**Planning Department
Transportation Development Services**

**Re: A-Tech Security
4616 Hawkins St., NE
Traffic Circulation Layout**
Engineer's/Architect's Stamp dated 5-25-16 (D17-D104)

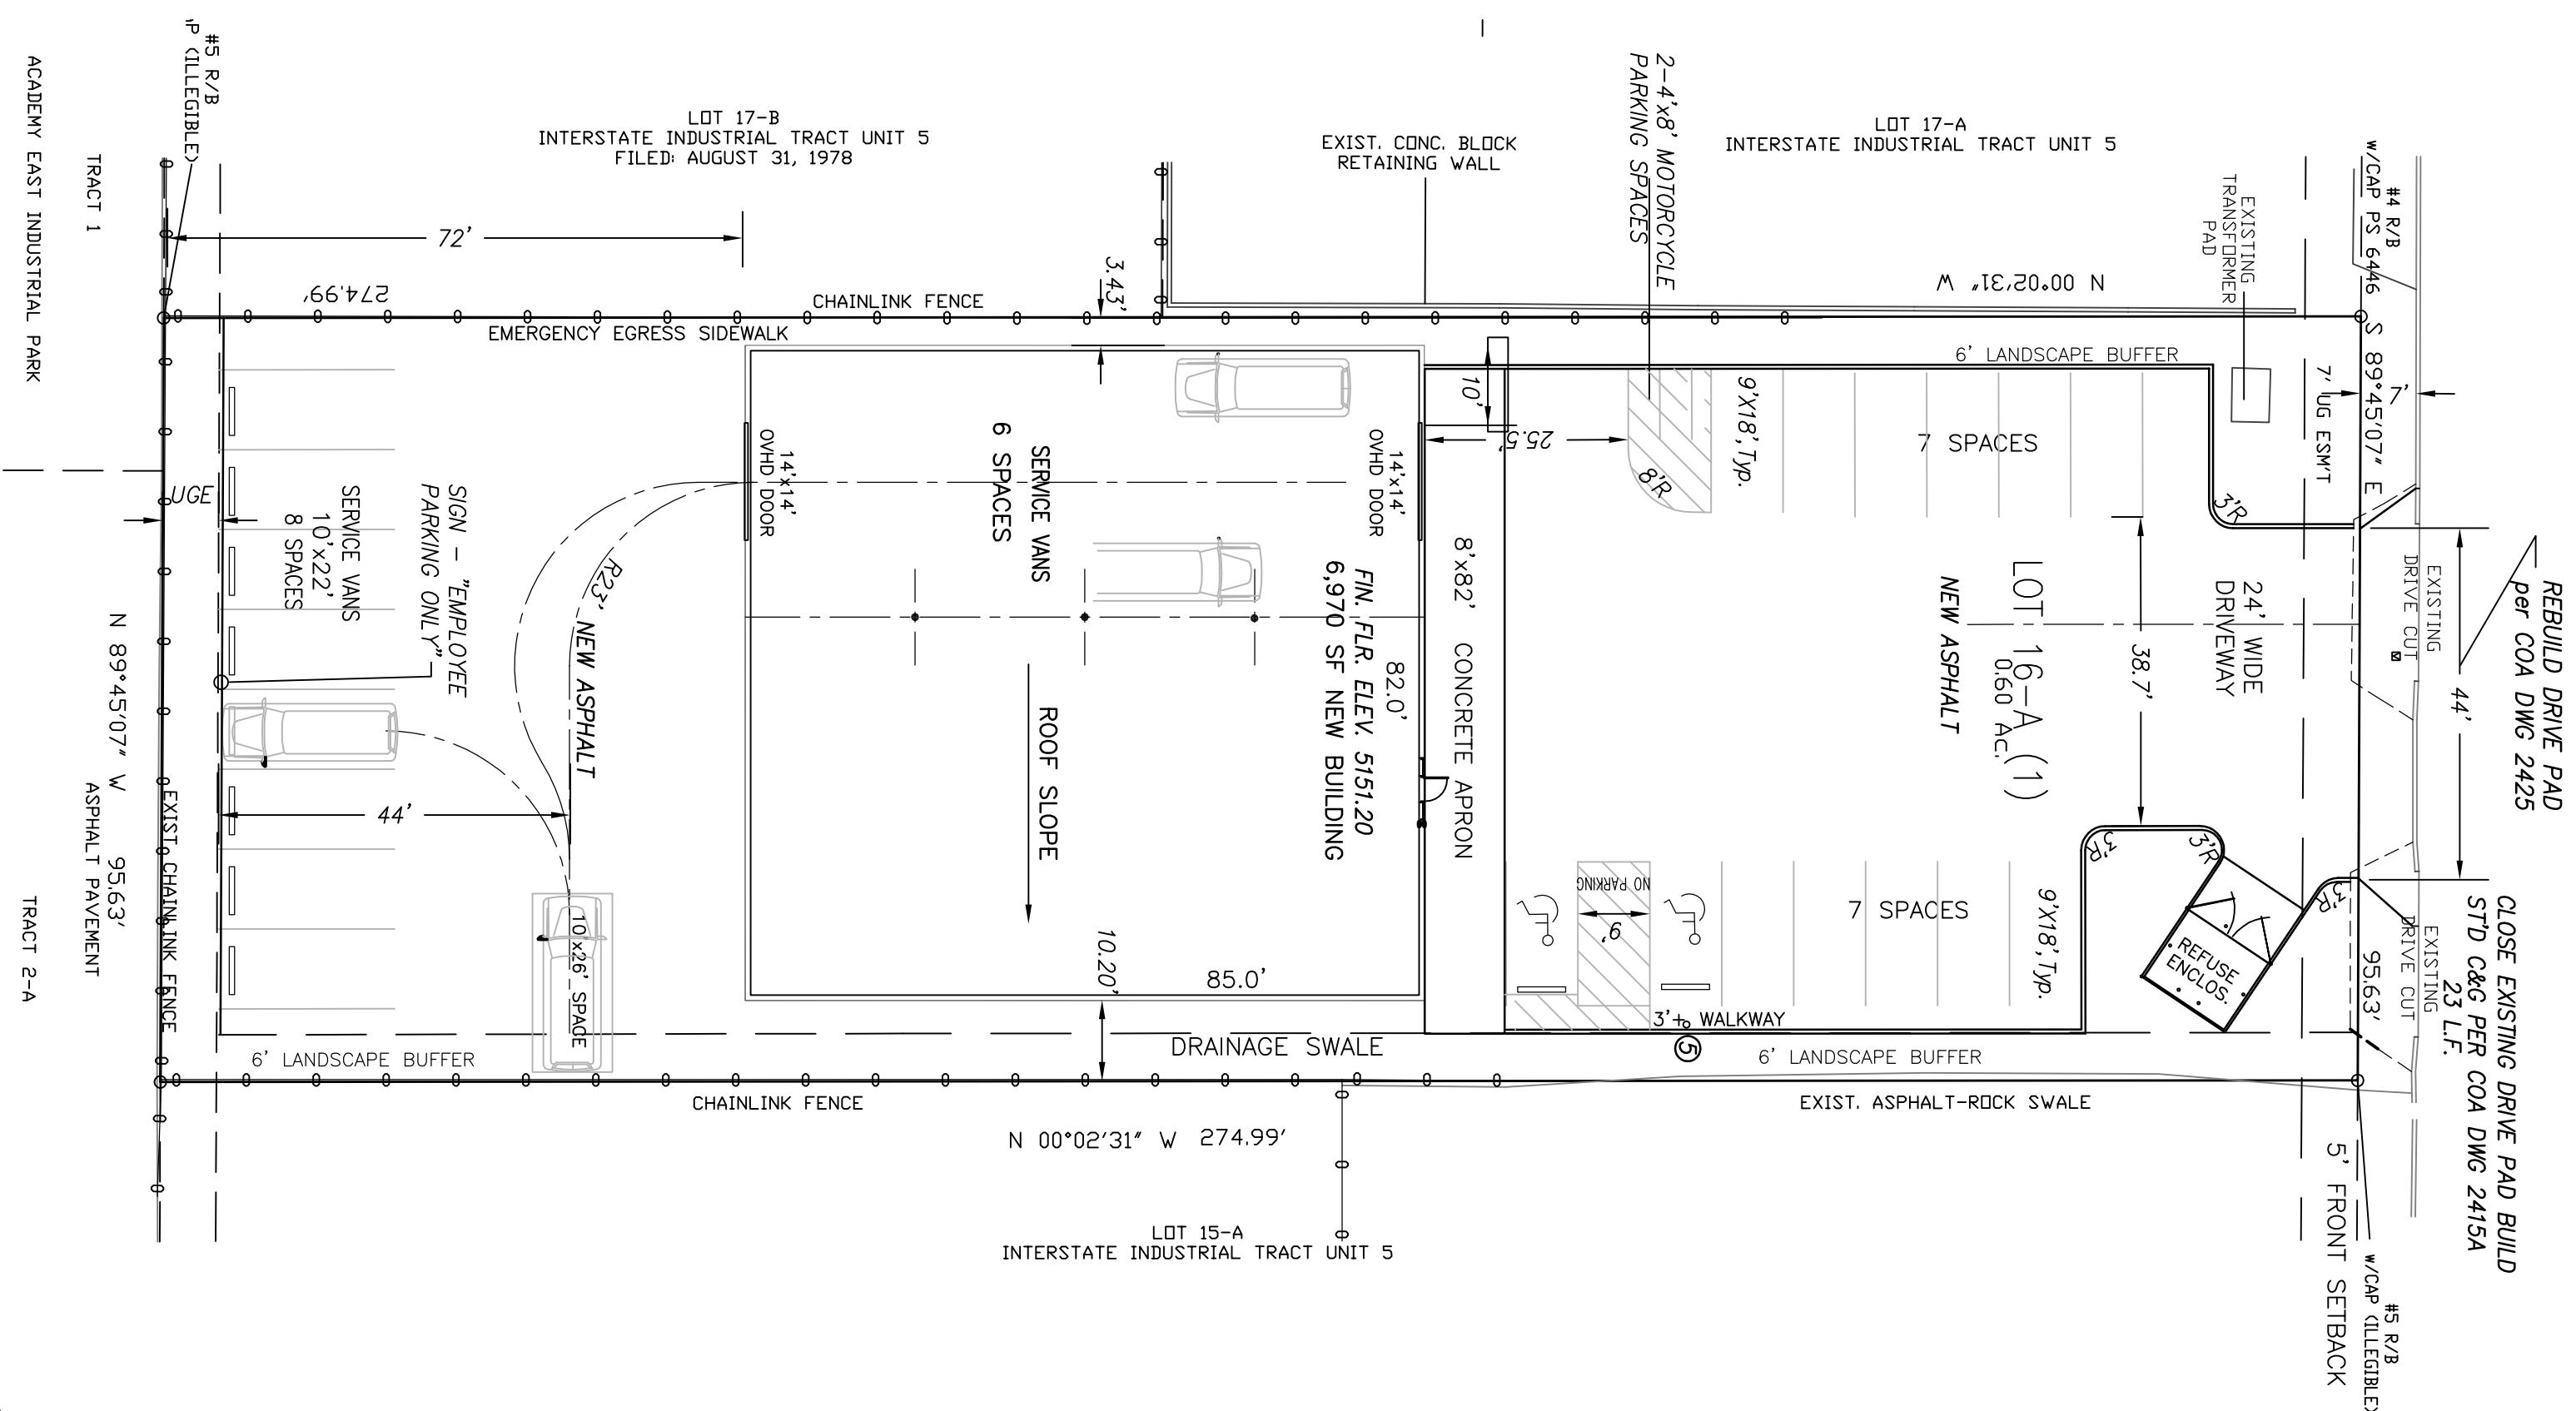
1. Please state the type of material to be used for the parking lot on the south end of the project site.
2. Per the DPM, a 6 ft. wide ADA accessible pedestrian pathway is required from the public sidewalk to the building entrances. Please clearly show this pathway and provide details from Hawkins St. Provide detail of ADA ramp from public R.O.W.

3. Per the DPM, a 6 ft. wide ADA accessible pedestrian pathway is required from the HC parking stall access aisles to the building entrances. Please clearly show this pathway to the building entrance. The ADA path must not have pedestrians crossing behind parking spaces. Please reconfigure pathway to the east of the HC parking spaces.

4. Provide a min 6" or max 8" high concrete barrier curb or other acceptable barrier between landscaping and parking areas and/or drive aisles.
5. Service vehicle and/or refuse vehicle maneuvering must be contained on-site; provide a copy of refuse approval.

6. Please add signage stating that parking in the bay and on south end of building is for employees only.

7. Please provide a sight distance exhibit (see the *Development Process Manual, Chapter 23, Section 3*). Please show this detail for the entrance/exit on Hawkins St.

8. Unused curb cuts must be replaced with sidewalk and curb & gutter. A build note must be provided referring to the appropriate City Standard drawing.
9. Please include two copies of the traffic circulation layout at the next submittal.
